**BCA ASSESSMENT REPORT
SMALLS ROAD SCHOOL DEVELOPMENT**

August 2017

Ref.: 160339

Smalls Road School Development

1 North East Elevation
2100 1:200

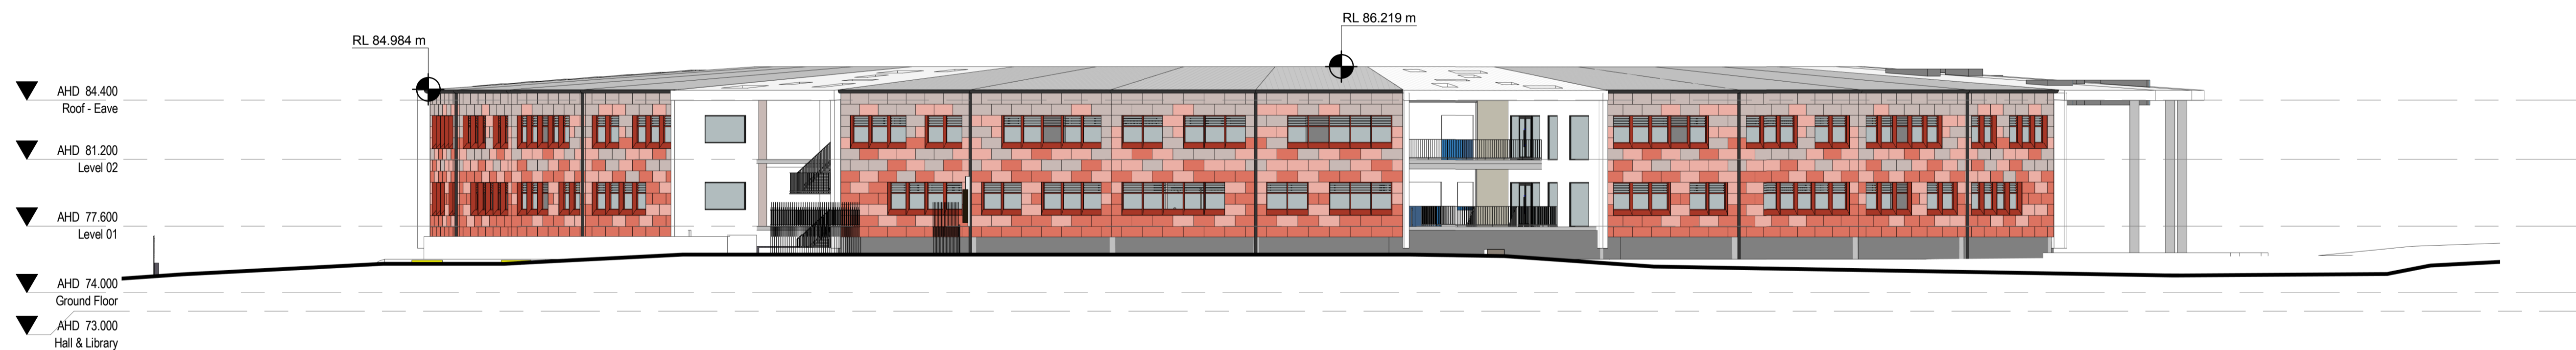
2.	C2.6	Spandrel protection is required. Architectural elevations are to be provided for assessment.
3.	C3.2	Where interallotment boundaries are not proposed to be extinguished, and is within 3m of the subject building, we recommend this be subject to a Fire Engineered Performance Solution to justify proximity to a fire source feature.

Clause C2.6 (Spandrels) Spandrel protection is required for external walls at Level 1 and 2. Compliance is readily achievable, architectural elevations are required to demonstrate compliance through the provision of either:

- + A vertical spandrel which achieves an FRL of 60/60/60 having an overall height of 900 mm or more, extending at least 600 mm or more above the upper surface of the intervening floor, and;
- + A horizontal projection (balcony) which achieves an FRL of 60/60/60 having an outwards projection from the external face of the wall of 1100 mm or more, and an extension along the wall beyond the openings of at least 450 mm
